**Re: Response to State Environmental Policy Act (SEPA) Comments on the Westside Solar Project (CU-19-00003)**

Thank you for providing your review comments on the Westside Solar Project (Project). This letter is intended to provide specific responses to comments included in your letter, dated December 16, 2019.

Project Area
	Sample Plots
	Wetland 1
	50ft Wetland Buffer
	Wetland 2
	25ft Wetland Buffer
	Stream
	20ft Stream Buffer

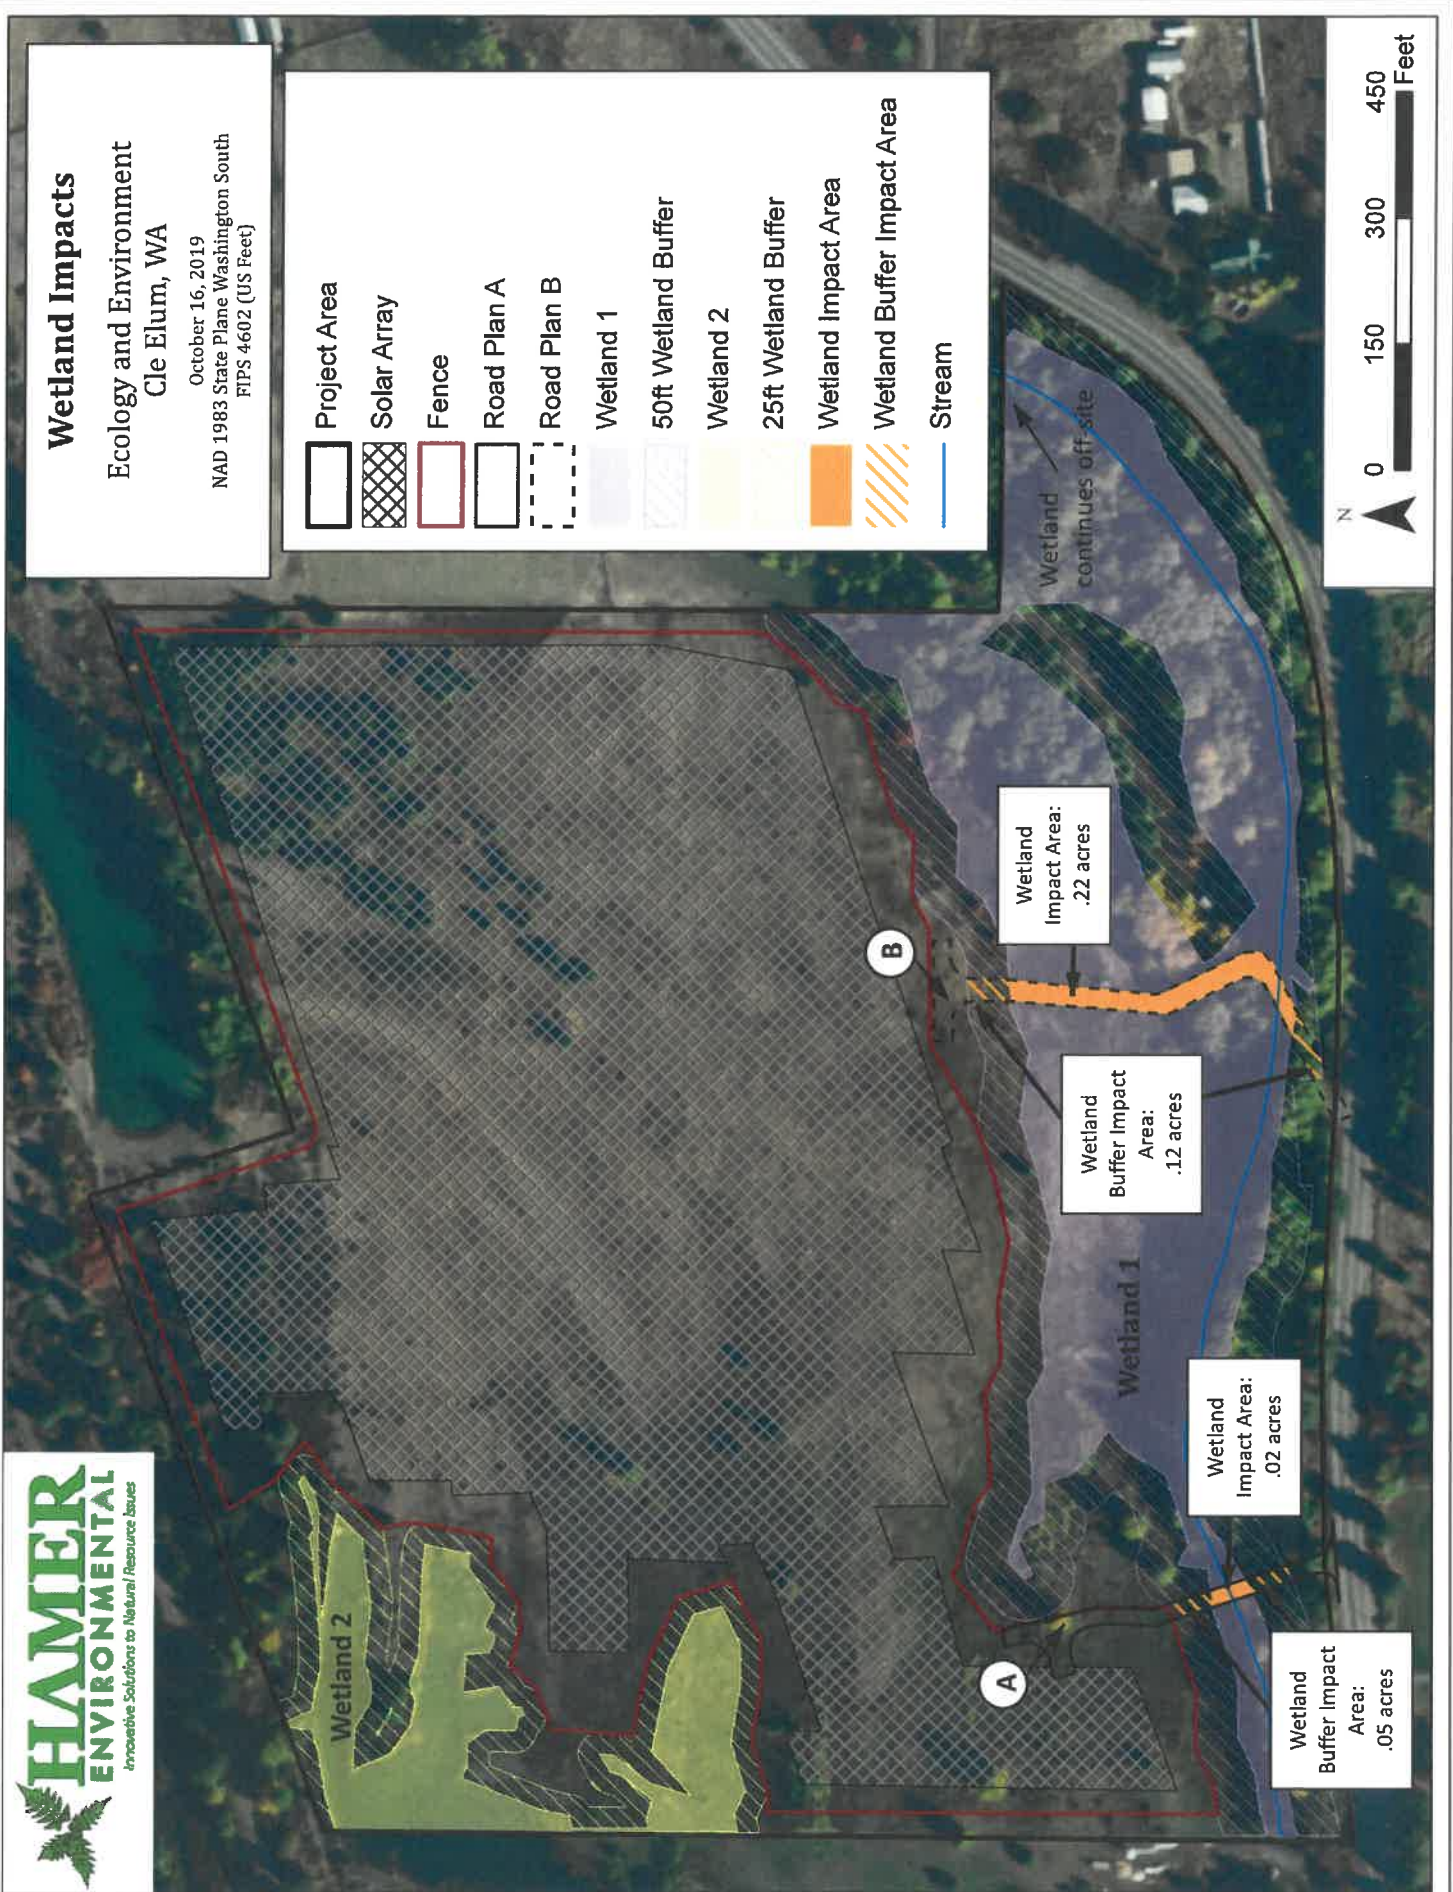
*Wetland 2, which will not have any direct impacts, has a proposed 25 foot buffer. Ecology recommends the County to use their widest Category II wetland buffer. Solar farms are considered a high land use intensity and to properly buffer a Category II wetland with a habitat score of 7, Ecology's guidance requires a 150 foot wide buffer. The County's Critical Area Ordinance for Category II wetlands, requires between 25 to 100 feet of upland buffer. Therefore, Ecology would recommend the widest buffer the County's CAO authorizes, which is 100 feet landward of the wetland boundary.*

*Wetland 1, is a Category I wetland with special characteristics (aspen stand) and a high score of functional habitat (8). This wetland will be impacted; therefore Ecology can require our regulatory buffer guidance to be used. A Category I wetland with a Habitat Score of 8, and surrounded by a high land use intensity would require a 200' wide buffer. However, there is opportunity to reduce the buffer width if the two items in Chapter 6.6.1.1 of Wetland Mitigation in Washington State, Part 1 can be met.*

Per Kittitas County Code, the specific development intensity for fixed-tilt and single-axis solar systems has not yet been determined. The applicant requests further information and guidance from the Washington Department of Ecology (Ecology) on how the determination of high land use intensity was reached.

**Regardless of development intensity, the Project requests that Ecology and Kittitas County consider allowing the proposed buffer widths in consideration of the overall benefit of this solar project as Washington transitions to renewable energy. The proposed buffers, in conjunction with the additional proposed wetland enhancement measures included in the Wetland Delineation and Conceptual Mitigation Plan, are intended to adequately protect the wetlands and preserve their functions and values.**

# Proposed Mitigation Plan

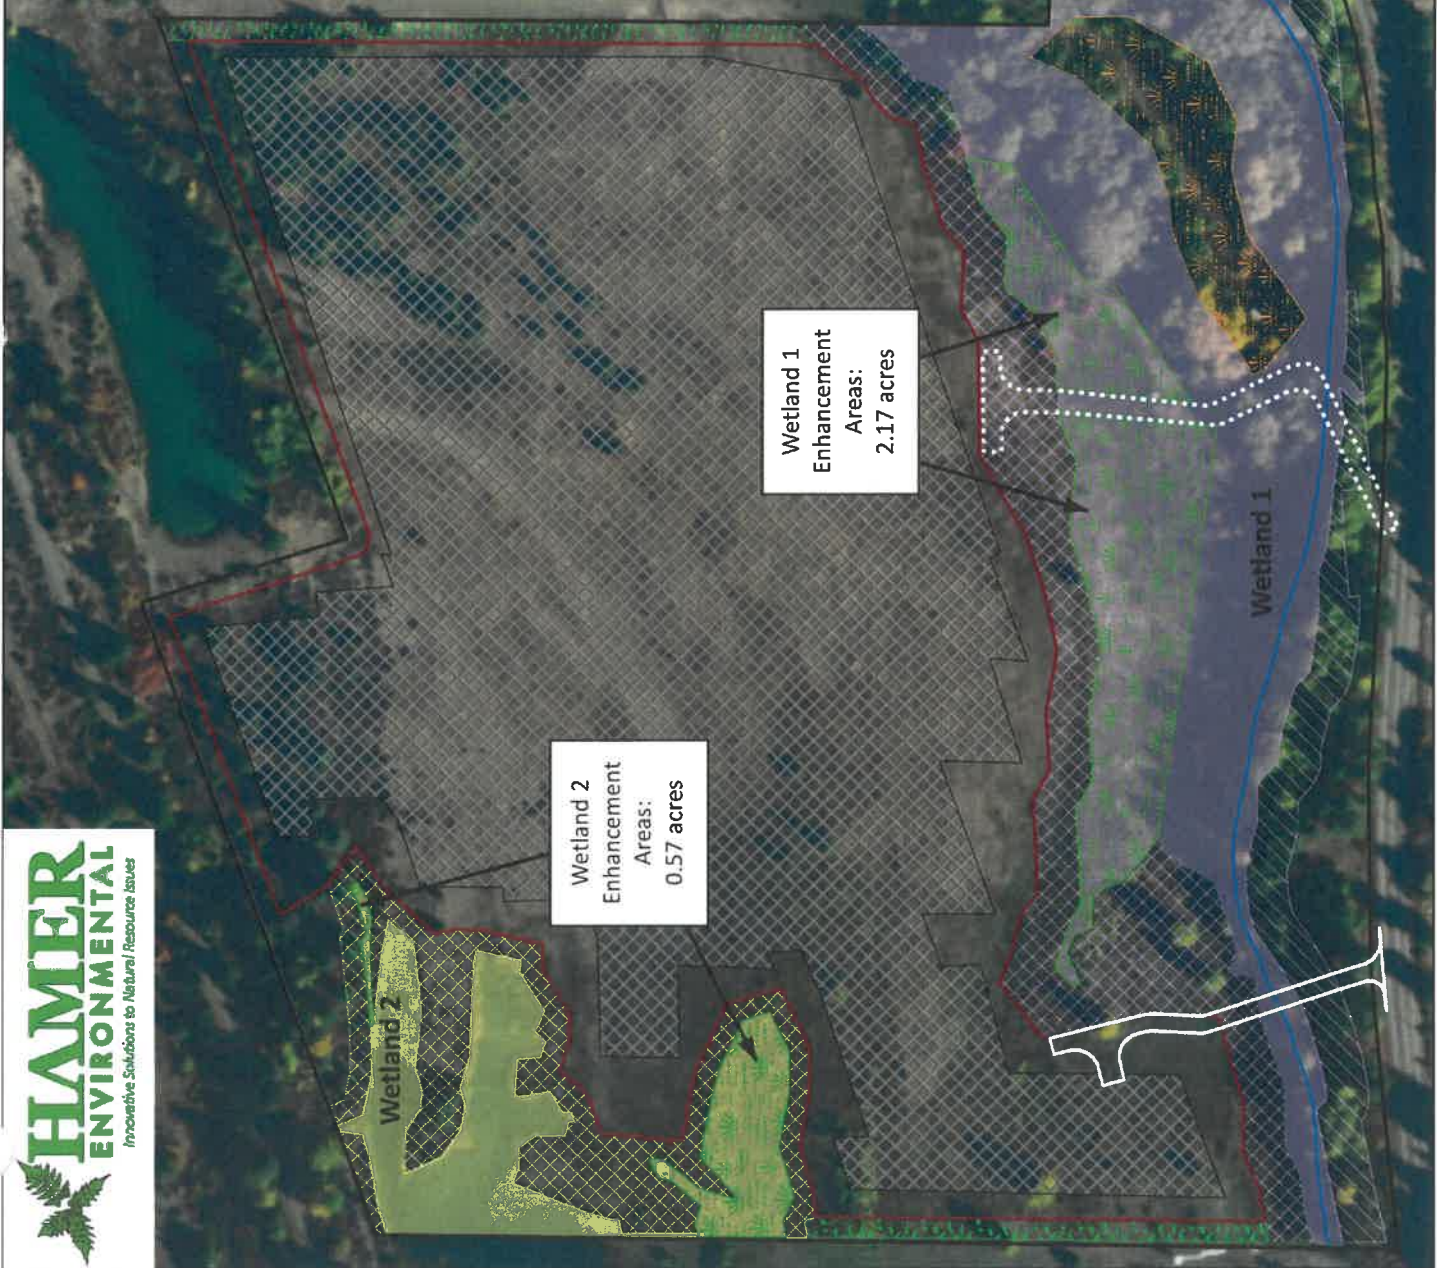
*Ecology would recommend access through Alternative A with the use of a culvert to provide hydrologic connectivity.*

Following submittal of the Conditional Use Permit (CUP) Application, Westside Solar has continued to refine the driveway design alternatives, including a conceptual grading design to determine the amount of fill needed to construct a fire code-compliant driveway at each of the alternative locations. The Project has concluded Alternative B would be the most appropriate access option from both a financial and impact perspective.

1. Further analysis during the conceptual grading design shows that while the footprint of Alternative A is indeed smaller, the volume of fill placed in the wetland is greater for Alternative A. This was documented in the Conceptual Layout Drawings provided to Ecology in advance of the site visit on 11/12/2019.

2. Kittitas County Public Works has granted preliminary approval to reduce the width of Alternative B from 26 feet to 20 feet, further reducing the footprint and volume of fill required to construct Alternative B.

3. The east-west portion of the driveway within the main portion of the site is required to provide vehicle access to all inverters and interconnection equipment areas, regardless of which Alternative is constructed. As a result, the total length of driveway required for Alternative A is similar to that of Alternative B.

4. The depth of fill required to construct a fire code-compliant driveway at Alternative A (20 feet above existing grade at its deepest point) could potentially create a barrier to wildlife movement through Wetland 1.

5. Although restoring the existing driveway at Alternative B would be considered a mitigation area, the existing functions provided by the undisturbed forested wetland that would be impacted by Alternative A far outweigh the functions of the previously disturbed wetland/buffer areas that would be impacted by Alternative B. The existing dirt access road at Alternative B has been previously impacted, consisting of compacted bare ground, generally free of herbaceous vegetation, and provides a low level of function.
